Transport Technical Note

Proposed Holiday Lodges

Whalley Rd, Hurst Green

26044 April 2026

Project Name	Project No.	Stage
Land off Whalley Road BB7 9QJ	185.23	Planning Submission
Location Plan 01	Scale Date	1:2500 @ A4 June 2025
Rev A	Drawn	ZM

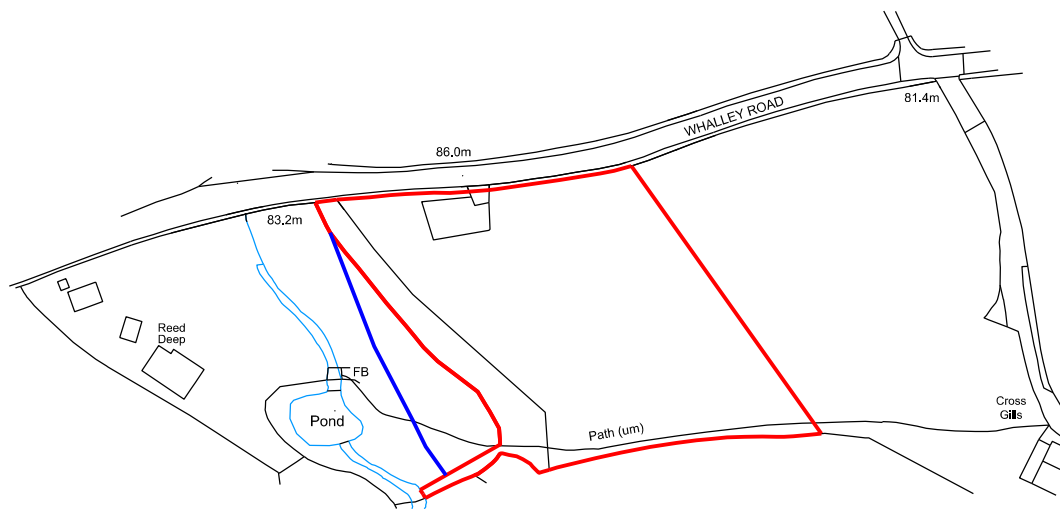
Some of the hedge running adjacent to Whalley Road will need to be lowered and is located in third party land, however the recently submitted drawings (30th March) are contradictory and confusing as they show different red line boundaries. The western boundary area differs on each drawing, with one drawing showing the red line boundary following the Title boundary (and therefore likely to be the correct boundary). An extract of that drawing (number 06 rev A) is shown below. This would also highlight that improvements to the public right of way would not be possible.

Project Name	Land off Whalley Road	Project No.	185.23	Stage	Planning Submission
Proposed site plan	03	Scale	1:500 @ A1	Date	June 2025
Rev A		Drawn	ZM

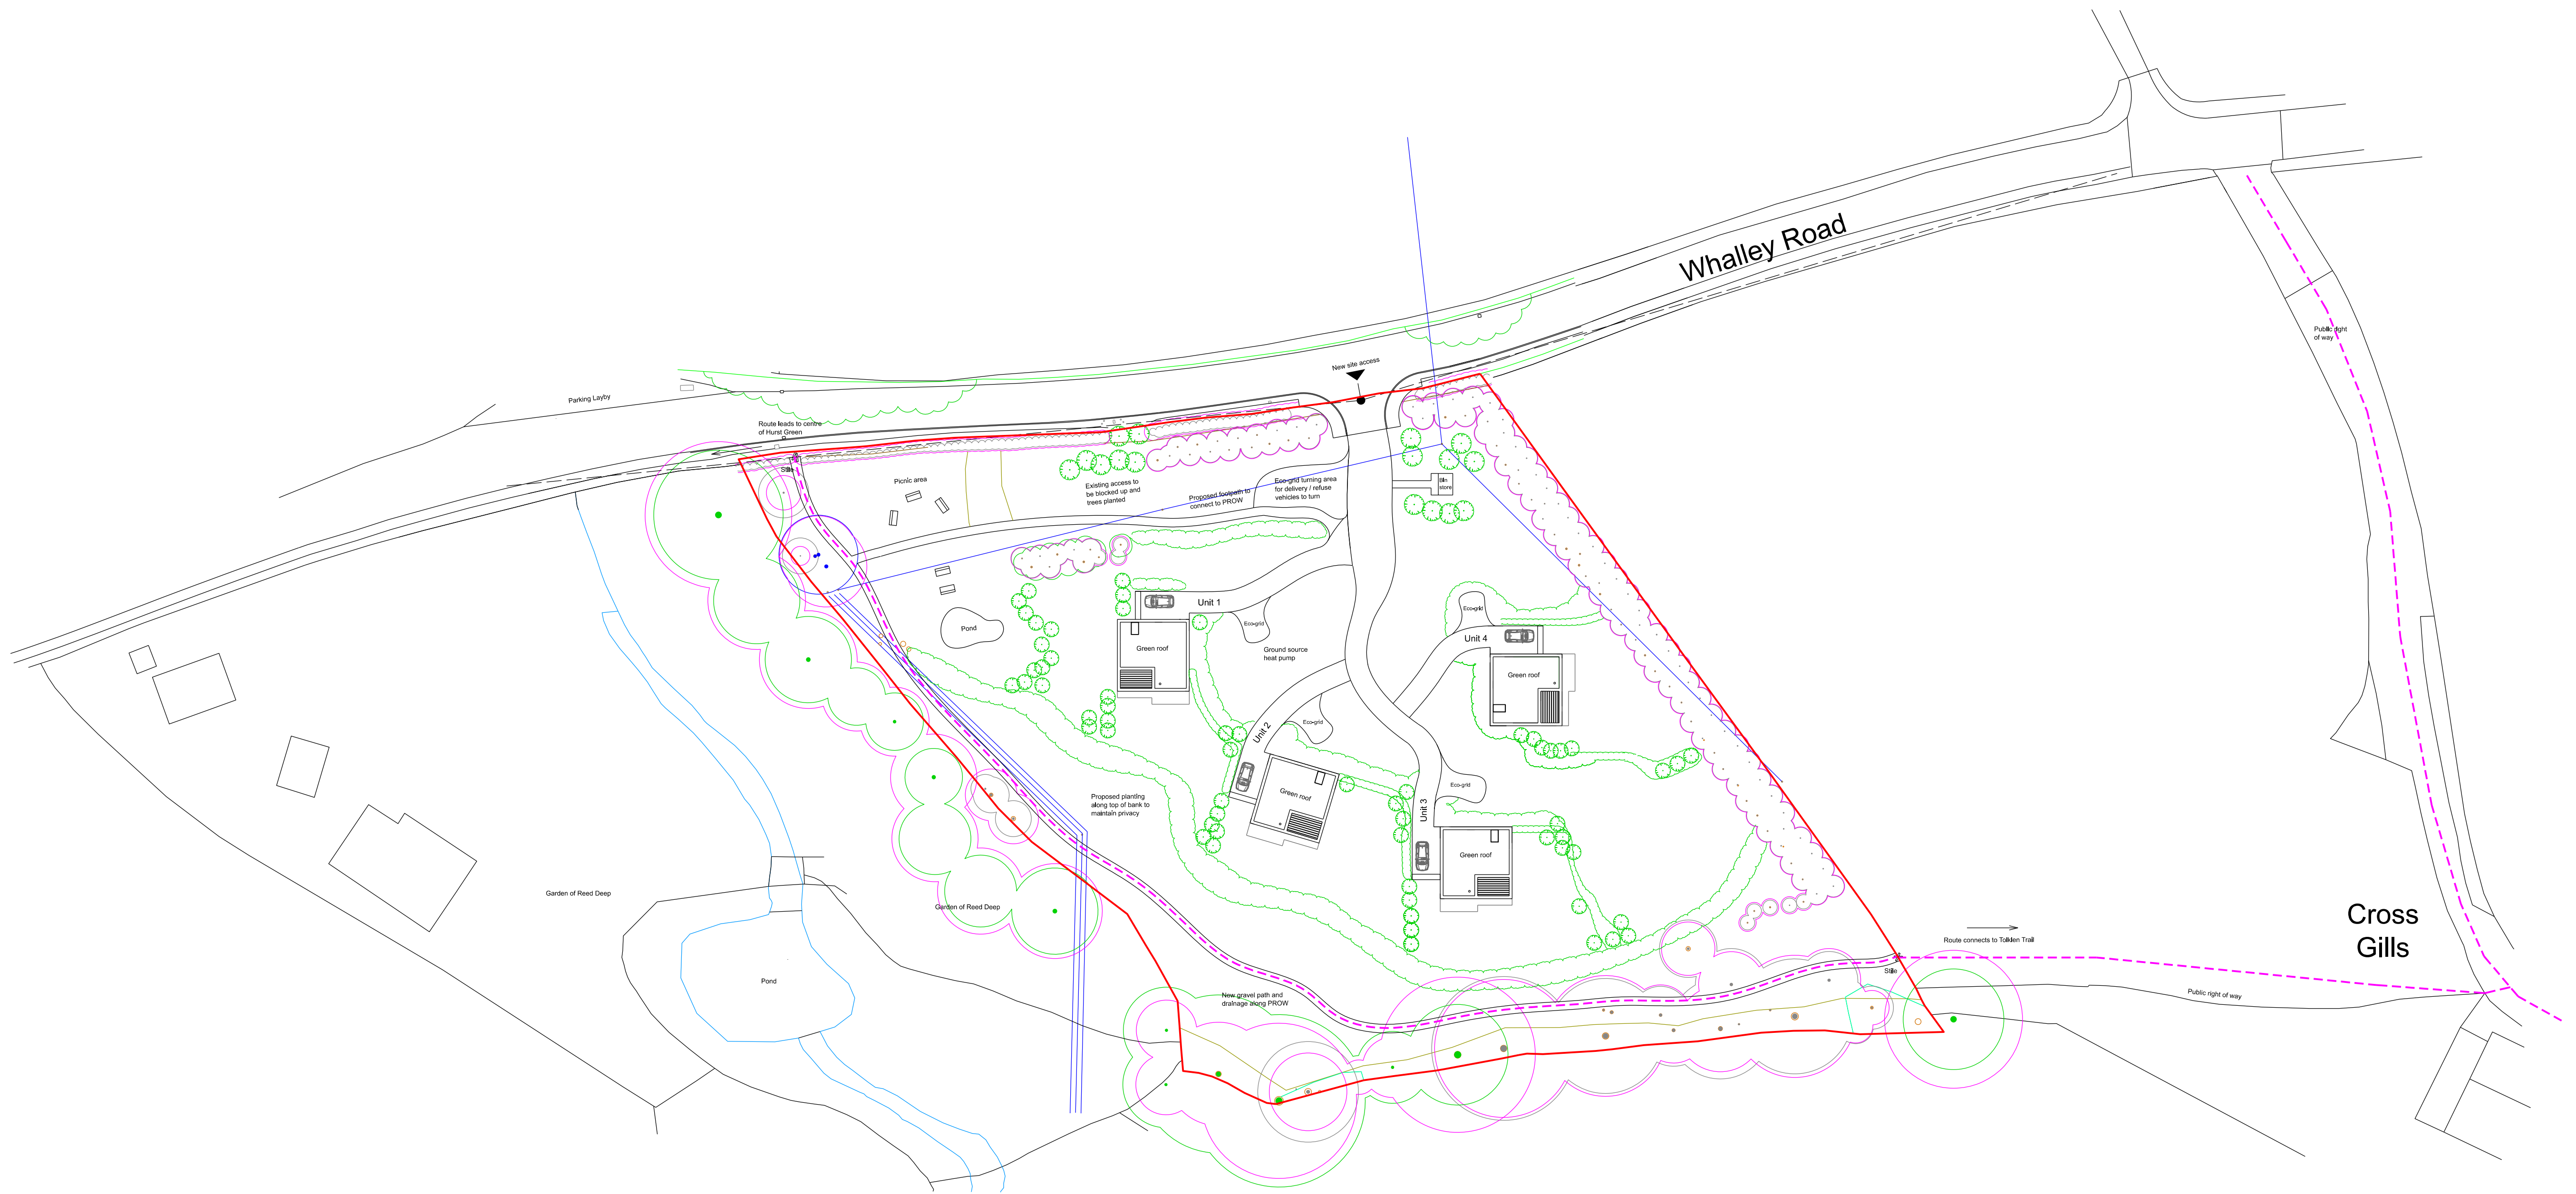
Furthermore, the hedge is shown behind the visibility splay and therefore indicating a relocated hedge (see extract of the applicant's drawing (number 03 rev C) below, and photograph showing the existing hedge significantly closer to the road edge).

The Highway Authority have advised that they will enforce the maintenance of the hedgerow to ensure it does not grow higher than 900mm. This hedge height is also not sufficient to facilitate any visibility splay given that the required object height of 260mm (or even 600mm) will not be visible if there is an adjacent obstruction 900mm high.
